Lendlease Level 14, Tower Three, International Towers Sydney Exchange Place, 300 Barangaroo Avenue Barangaroo NSW 2000

Re: Barangaroo South Stage 1B Deep Soil Zones

We have considered your email dated 1November 2016 with regard to the Planning Assessment Commission consent condition in Concept Plan MOD 8 to provide 2,000 m² of 3 m deep soil within the expanded Hickson Park.

BASEMENT SLAB EXTENT

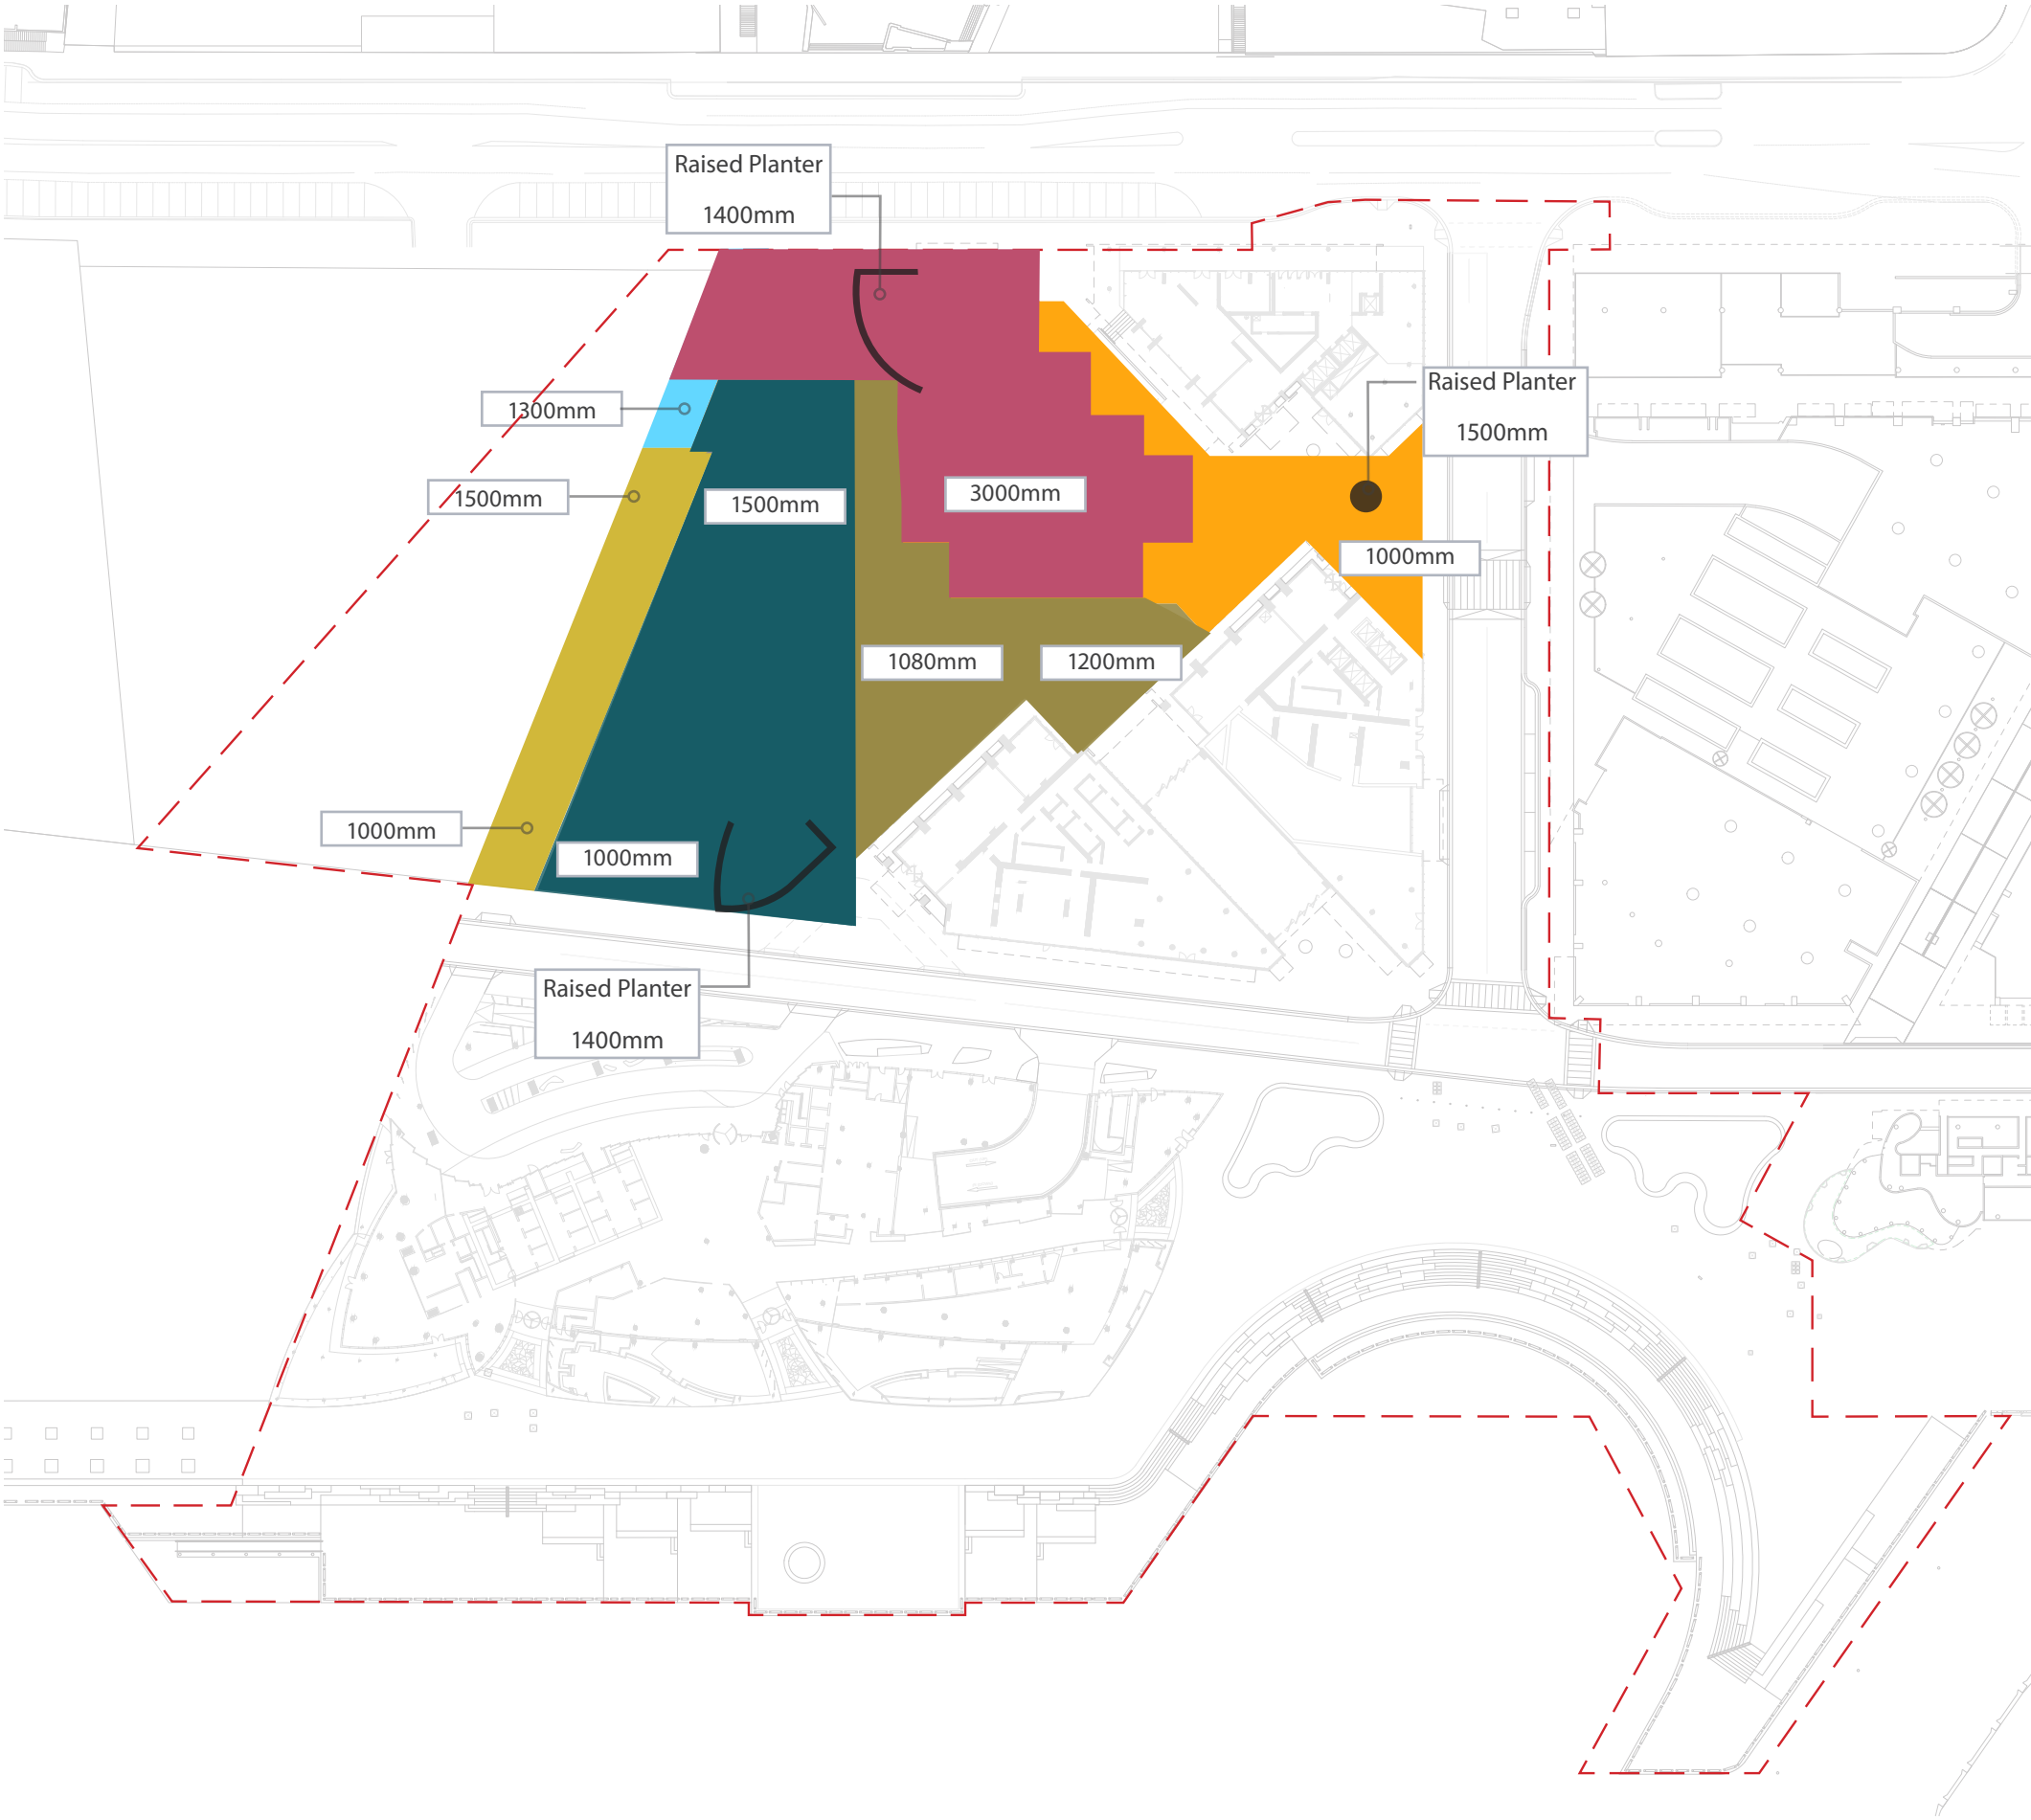
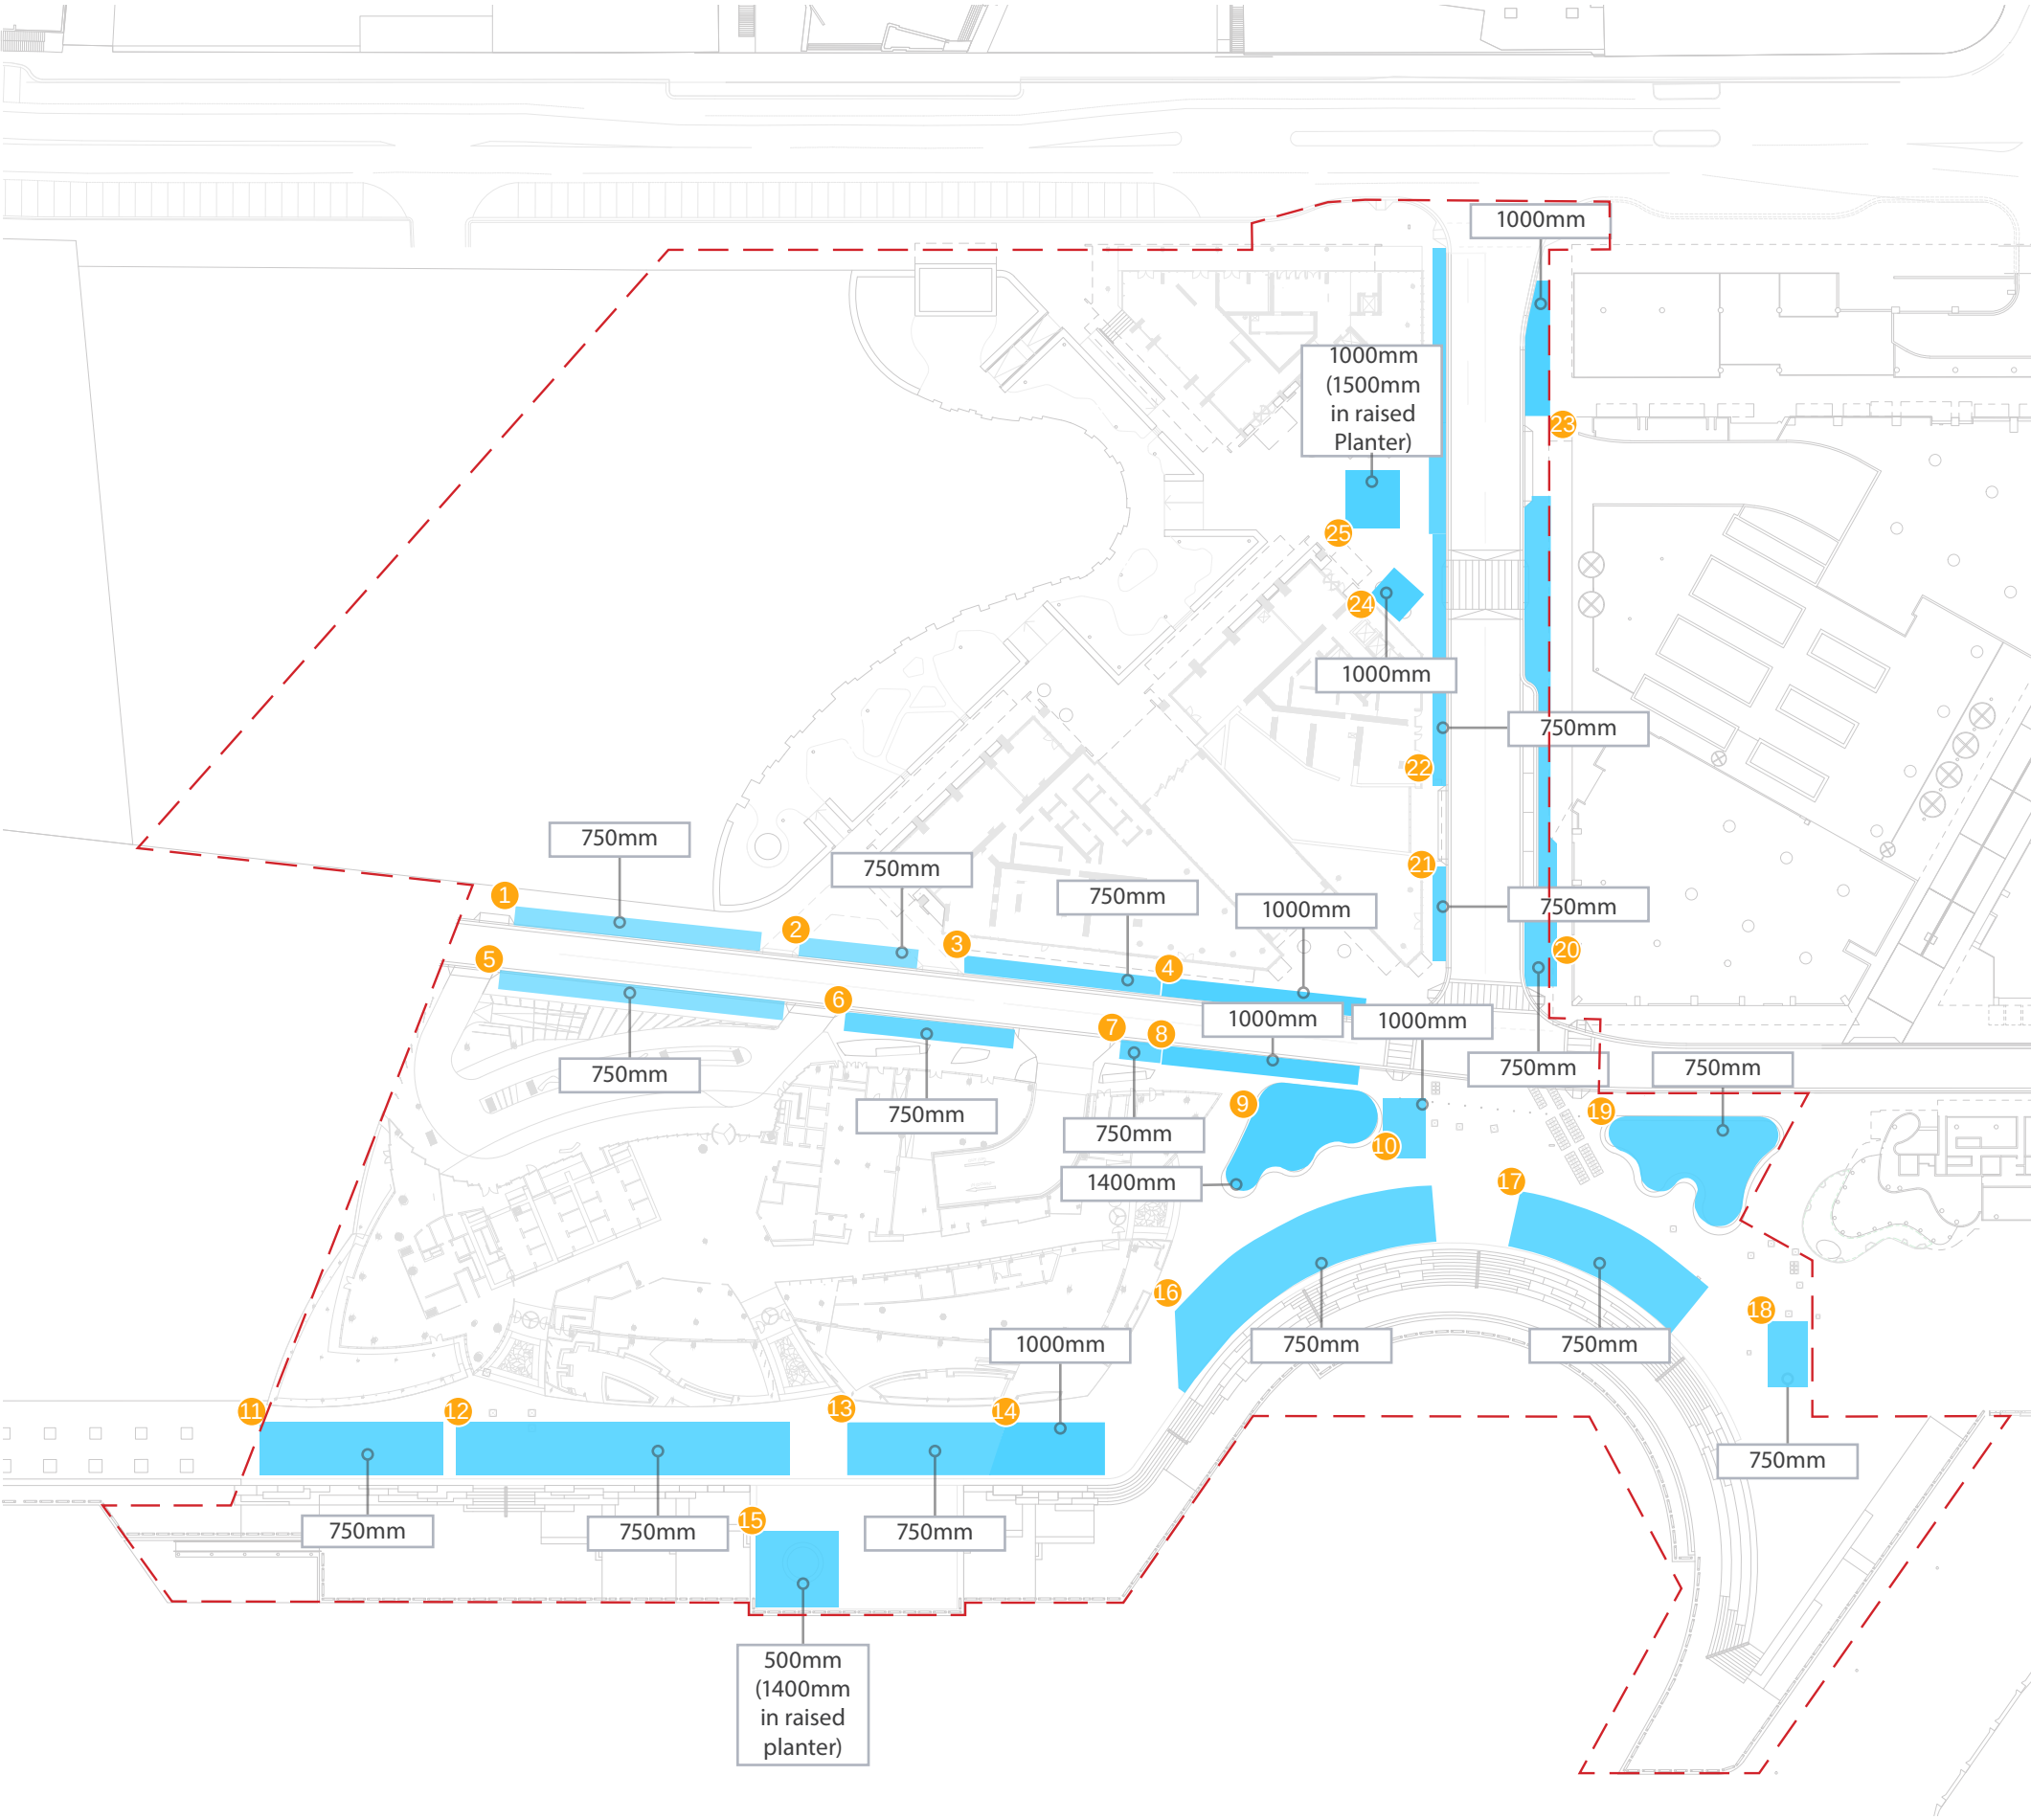
We do not know where the "deep soil zone" concept has come from but in our view it is wrong and demonstrates a fundamental misunderstanding of the structure of tree root systems. Contrary to the popular idea of the "root ball" trees in the great majority of soil types have a "root plate". The root "plate" develops as structural support root spread horizontally through the topsoil, rarely penetrating more than 500 mm. In order to drought-proof" itself the tree will send down "sinker" roots at intervals form the developing root plate. The concept of the "tap root" is also wrong in most soils; this is a juvenile structure only and develops into a "sinker root" in most cases.

It is our view that a profile depth of 1500 mm is necessary for the largest trees being Ficus species. Following our deliberations we are of the view based on the nominated largest species 1500 mm of soil being 500 mm of topsoil or A horizon and 1000 mm of subsoil B horizon would be adequate depth to establish and sustain the large trees. Given the nature of the compacted fill or concrete underneath drainage would be required, nominally 100mm so the actual soil profile would be 1400 mm deep.

3 m depth of soil is not necessary for the sustainable growth of even the largest trees chosen for the project and we are not aware of the factual basis upon which this requirement has been adopted. It is our view that half this depth is the normal requirement for the two very large specimens (Ficus microcarpa var. hillii and the Ficus macrophylla). Even lesser depths are needed for the rest of the medium and small trees to be planted on the site.

- A subsoil comprising well drained sandy loam with low organic matter and well balanced chemistry.
- 5. Where depths as shallow as 750 mm occur (which we believe occur in places), our advice would be to choose small trees only. Our suggested optimum from the table below is 900 mm but we believe 700 mm would be just adequate for smaller trees if irrigation is provided and lateral spread varies from 1.83m to 4.83 m. in width.

It is also our view that, provided the above criteria are met, even shallower profiles can be used for small and medium trees. As little as 900mm total (including the drainage layer) would be suitable for small trees in the planting pallet. The following table provides a guide for the species chosen for this project.
